November 29, 2012

Historical Preservation Board
City of Portland
389 Congress Street
Portland, Maine 04101

RE: Commercial and Middle Street Mixed Use Development
Foundry Lane comments, responses & revisions

EXPANDABLE TREE GRATE
NEENAH MODEL R-8810
NOT TO SCALE

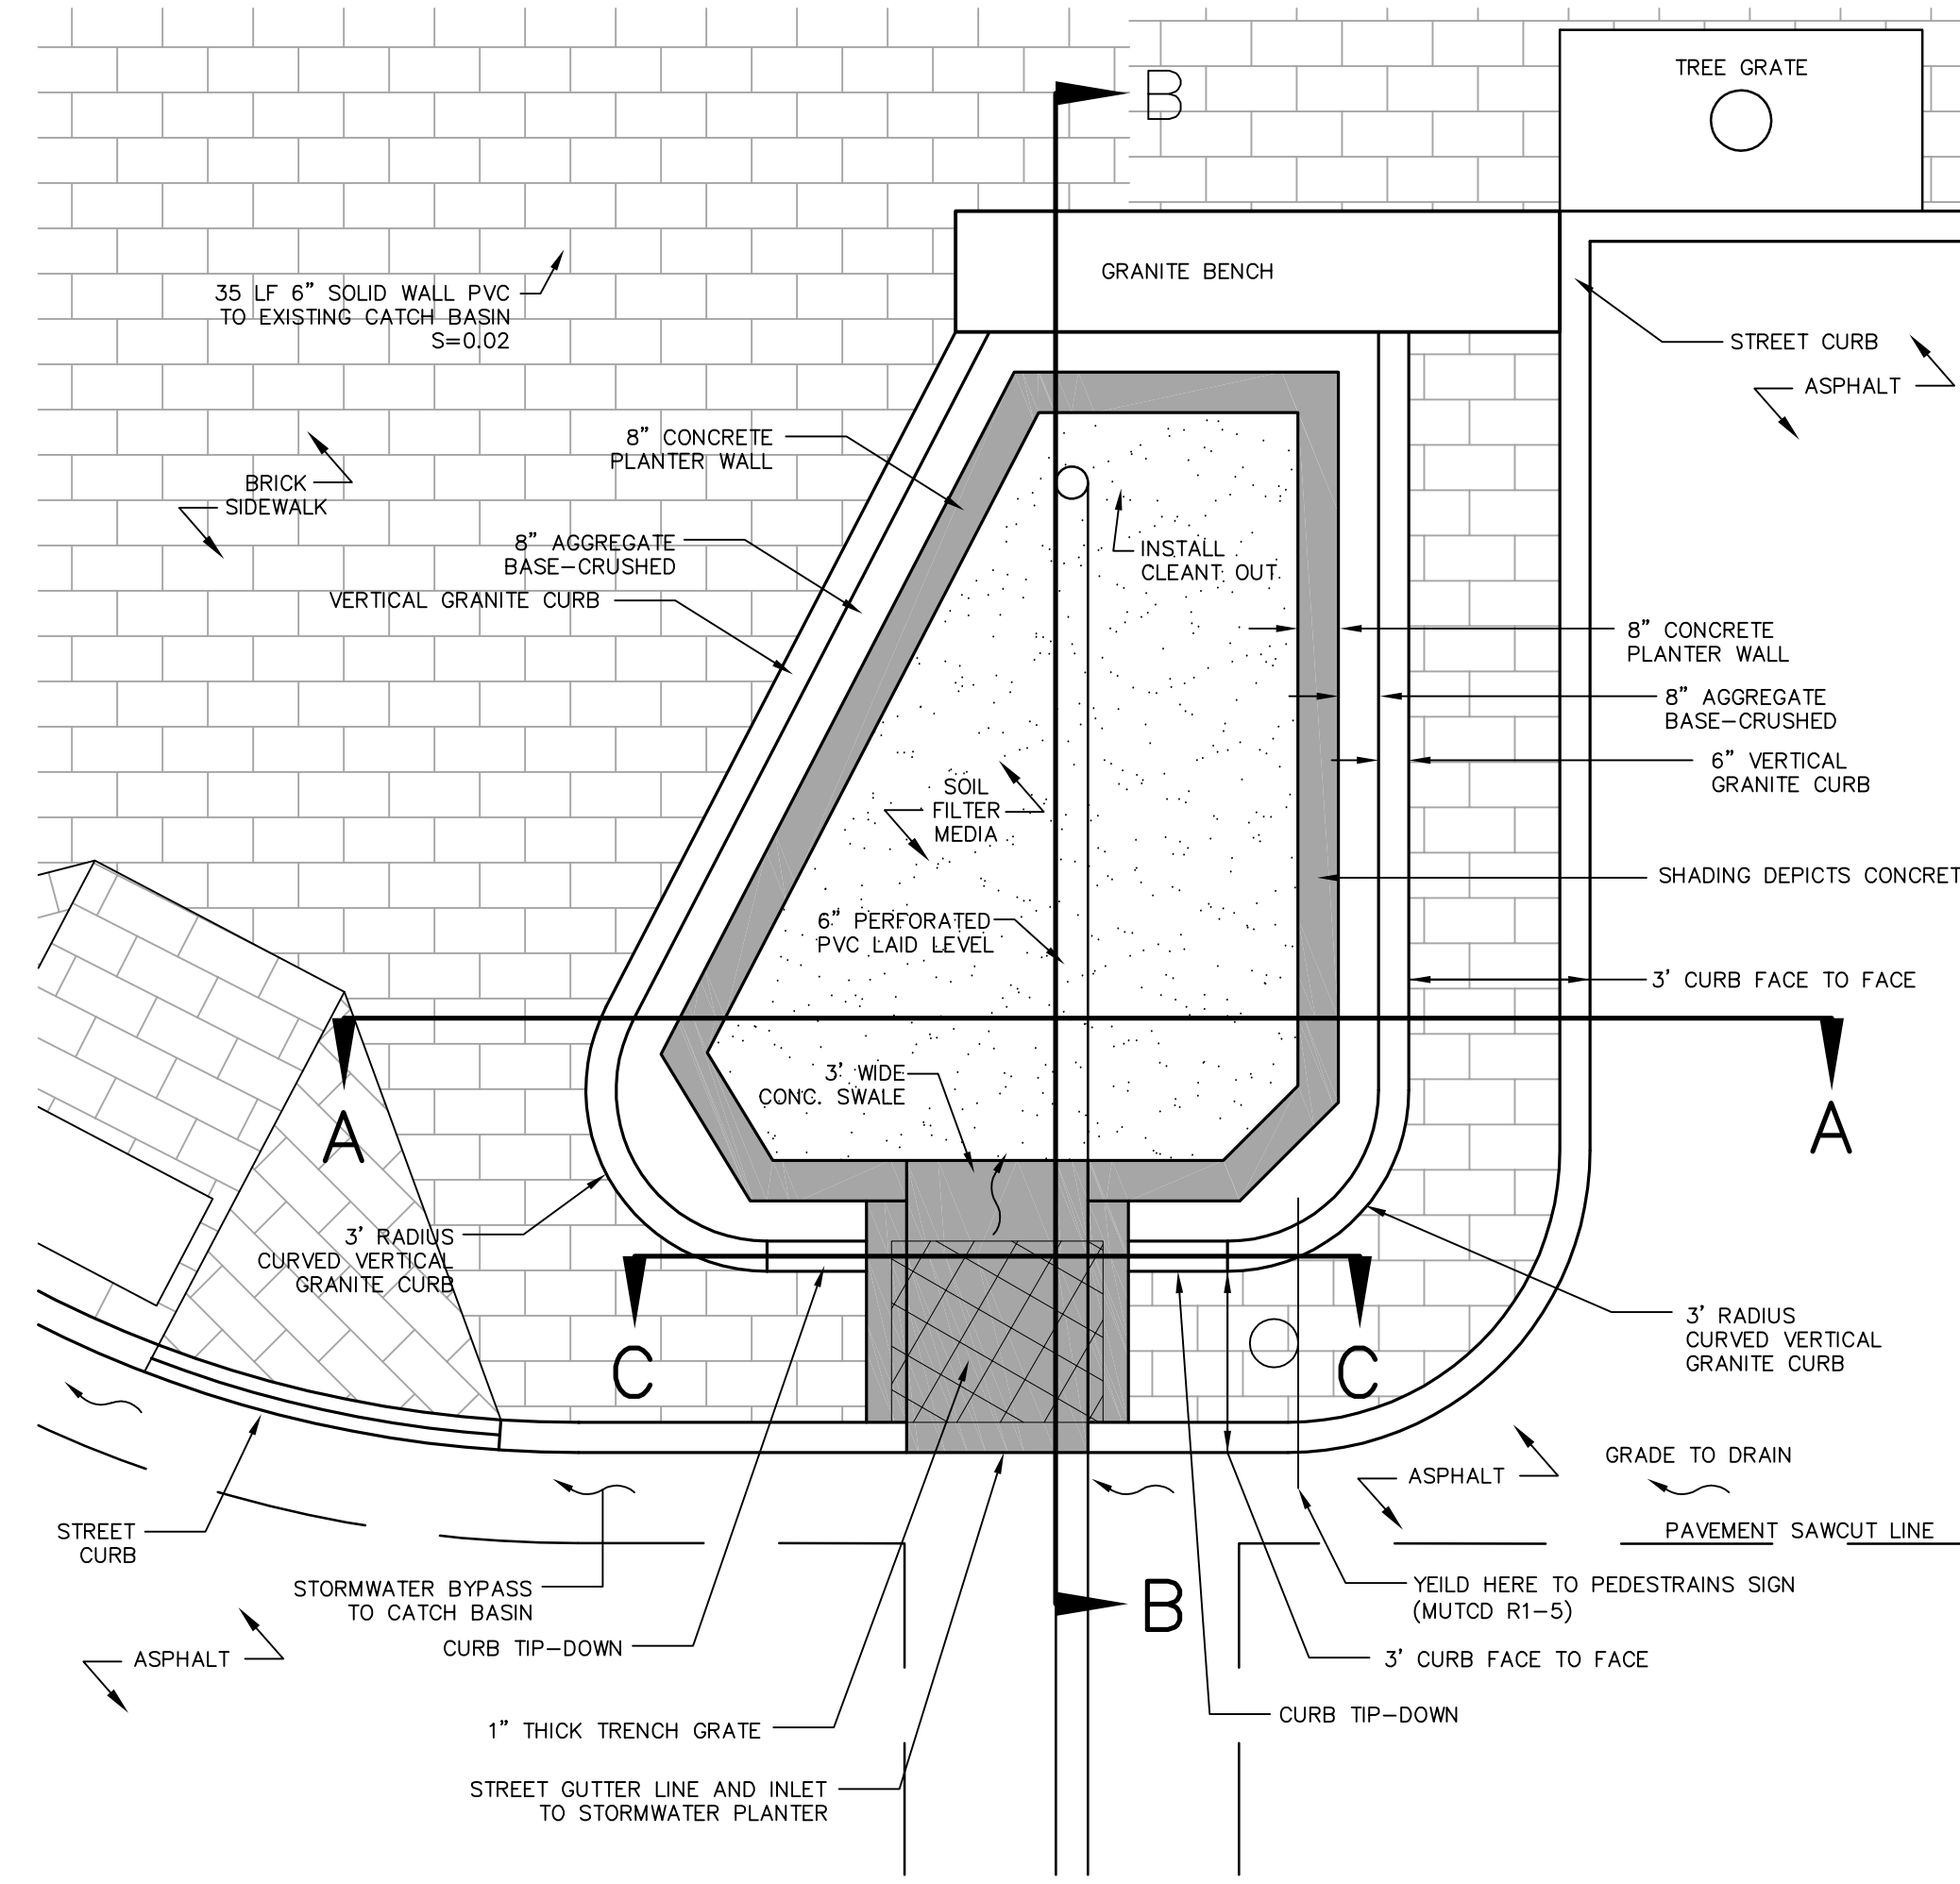
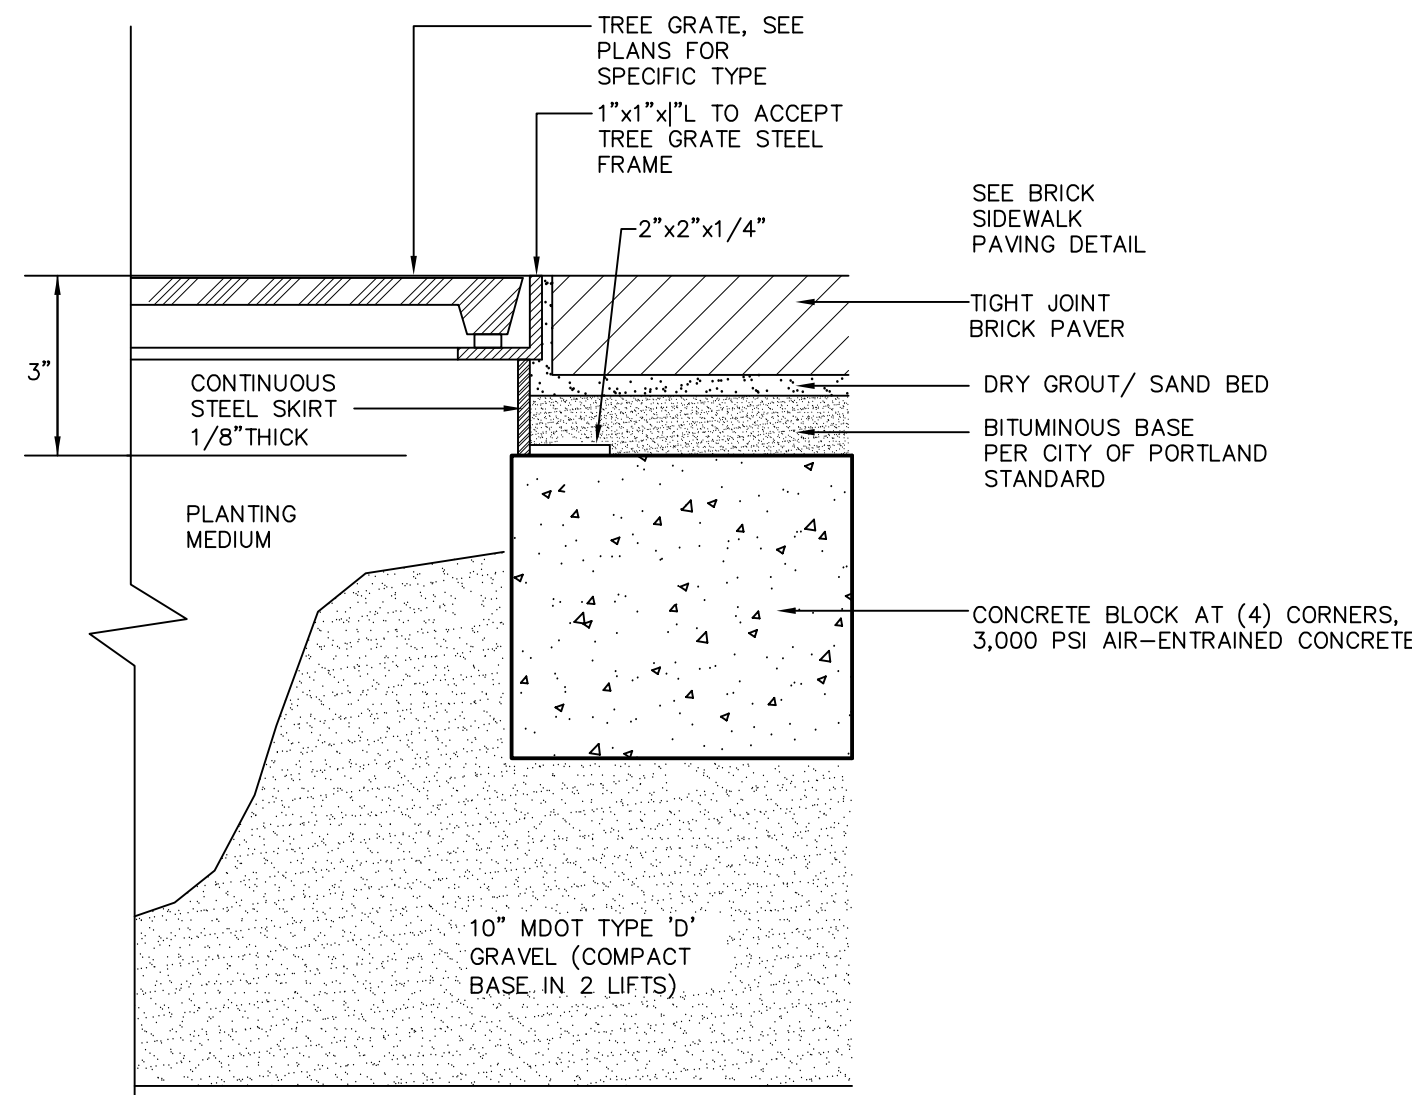
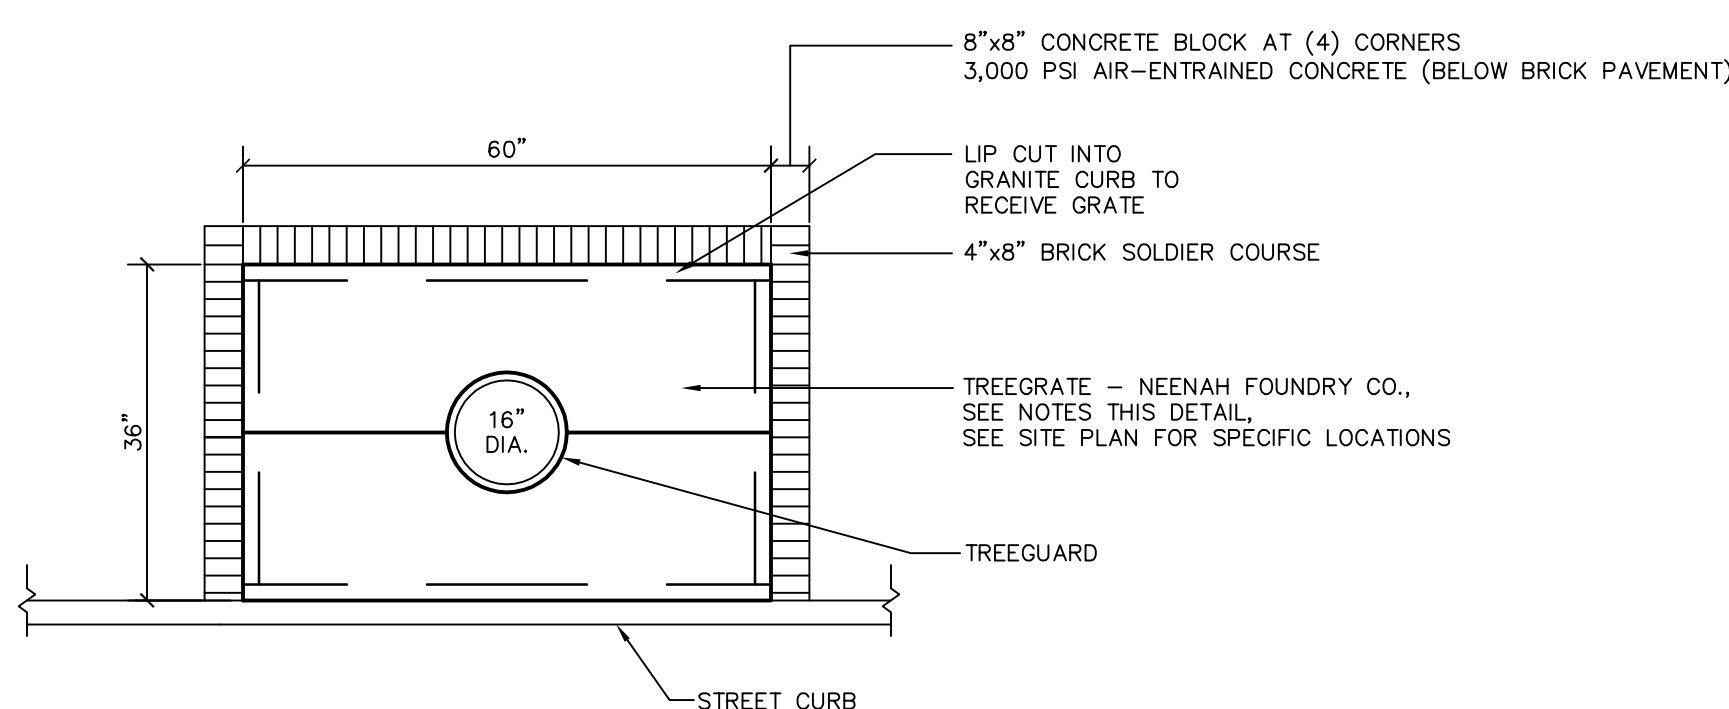
- ***We have implemented this revision.***
- Two trees in between suggested to have "Neenah Tree Grate R.8801" as indicated in handwritten note (so that they will survive)

- ***I believe this comment meant the Neenah Tree Grate R-8810 as required by the technical standards. The details in the site plans indicate this tree grate as required.***
